Recommendation Report for Planning Permission for Works or Extension to a Dwelling

REF NO: P/43/19/HH

LOCATION: 7 Drift Road
Pagham
PO21 3NX

PROPOSAL: Detached garage.

PROPOSED DETACHED GARAGE AT 7, DRIFT ROAD, PAGHAM FOR MR.D.GREENWAY

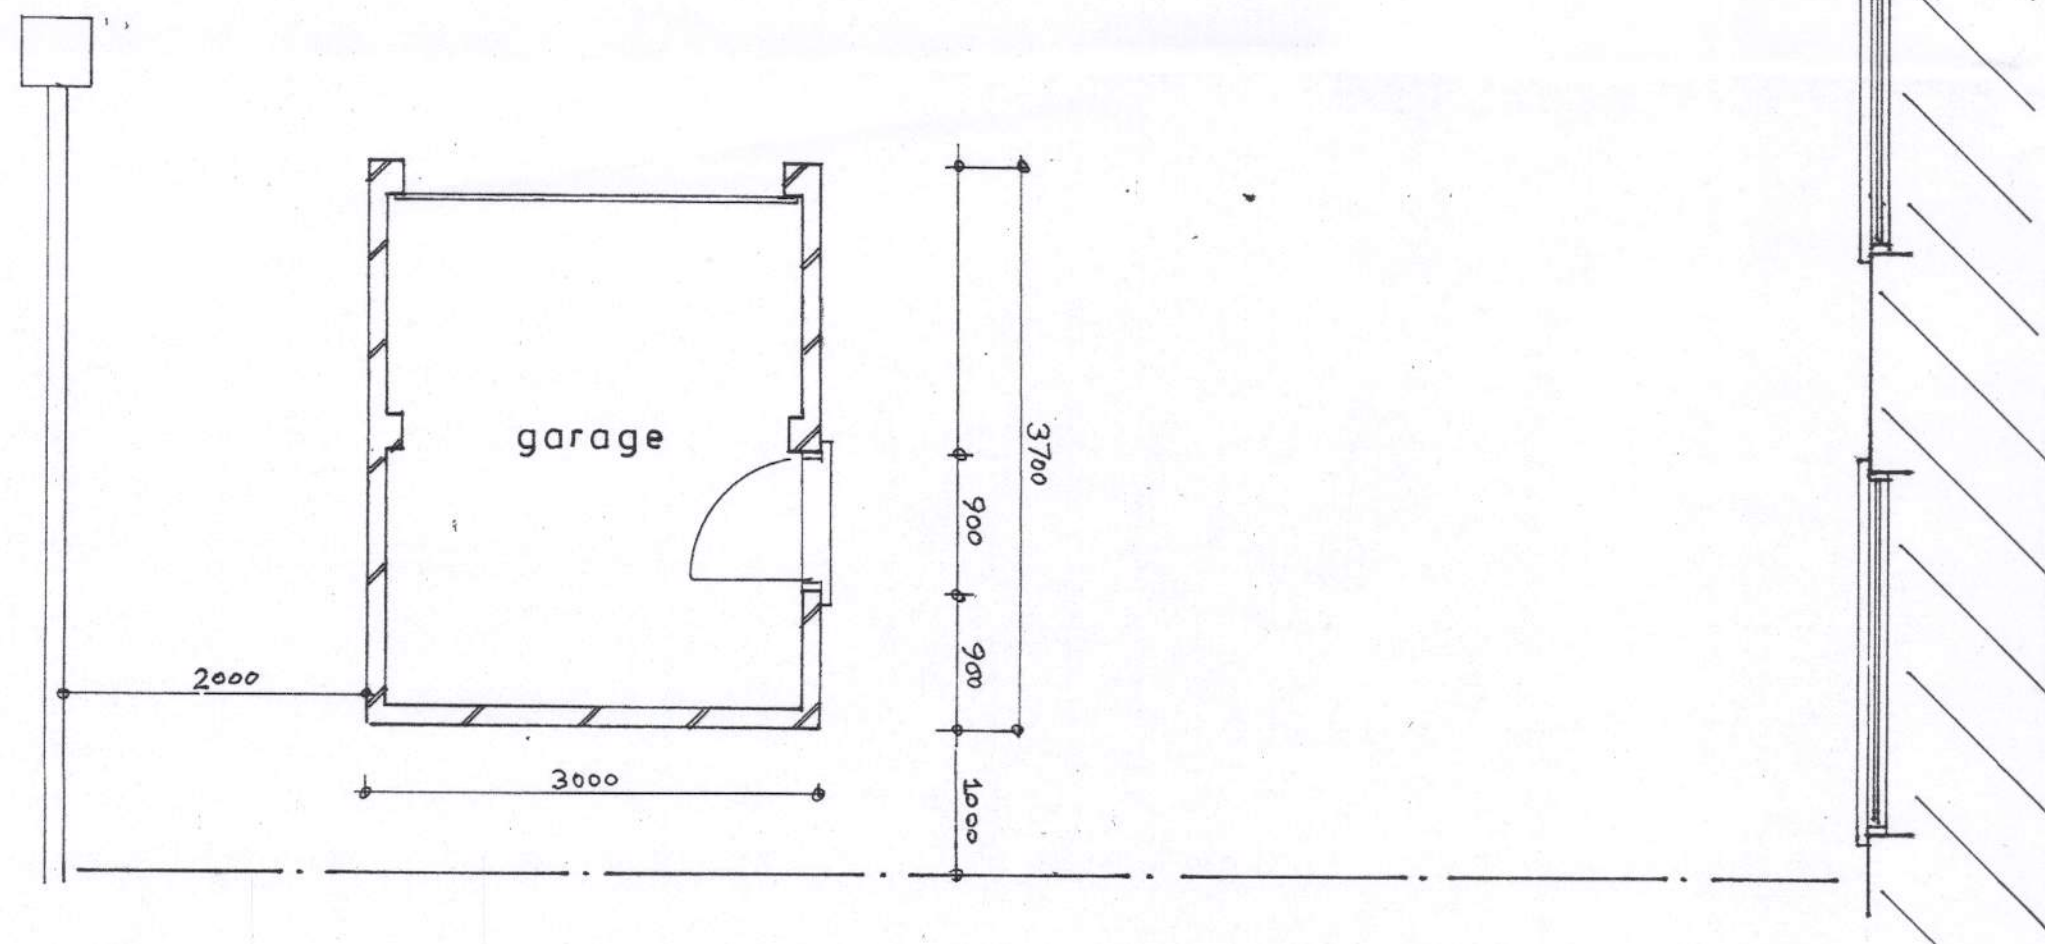
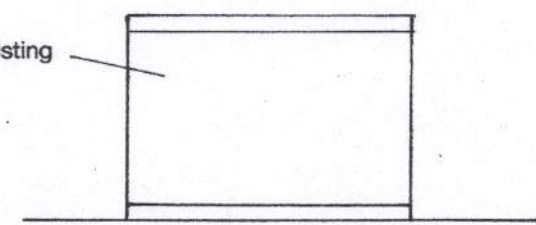
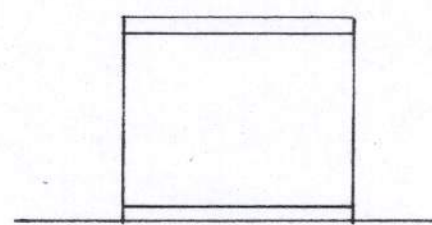
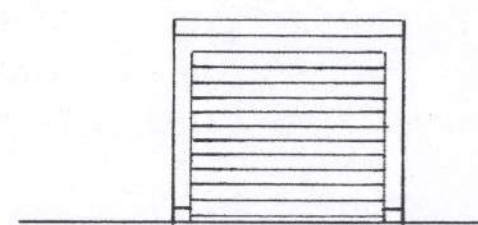
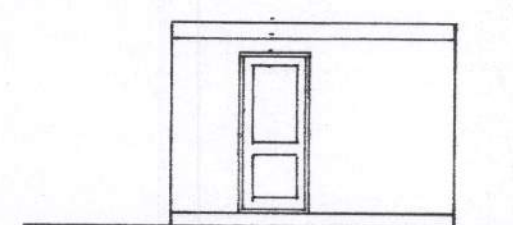
The garage is to be situated approximately 7m in front of the principal elevation of the dwelling and is therefore highly visible within the street scene retaining 2m to the road frontage.

There are no detached structures within the vicinity similar to that which is proposed with the development sited significantly forward of the established development line. As a result of its siting it is considered that when viewed from the road the extension will be visually prominent and appear as unduly dominant feature in the street scene.

Whilst the garage is modest in height at 2.7m there is little boundary to the front of the dwelling and neighbouring properties with the area having an open appearance and therefore this allows views of the garage from both the east and western elevation and as such is considered to appear adversely out of character and impact on the established spatial pattern of the locality.

The garage is of a basic, utilitarian design of no merit. As stated above it would be highly visible.

The garage will have a width of 3.7m and depth of 3m. Due to its position away from neighbouring dwellings it is not considered to give rise to any adverse impacts upon neighbouring amenity.

A door will be sited to the north elevation which will face the front elevation of the dwelling however the garage is single storey and resultantly the available views would be no different from those that are currently available from the front garden.

- 1 The development by virtue of its siting to the front of the property and design appears unduly

dominant in the street scene and incongruous to the pattern of development in the area resulting in an unacceptable impact upon the character and appearance of the locality and in conflict with policy DDM1 of the Arun Local Plan and the NPPF.
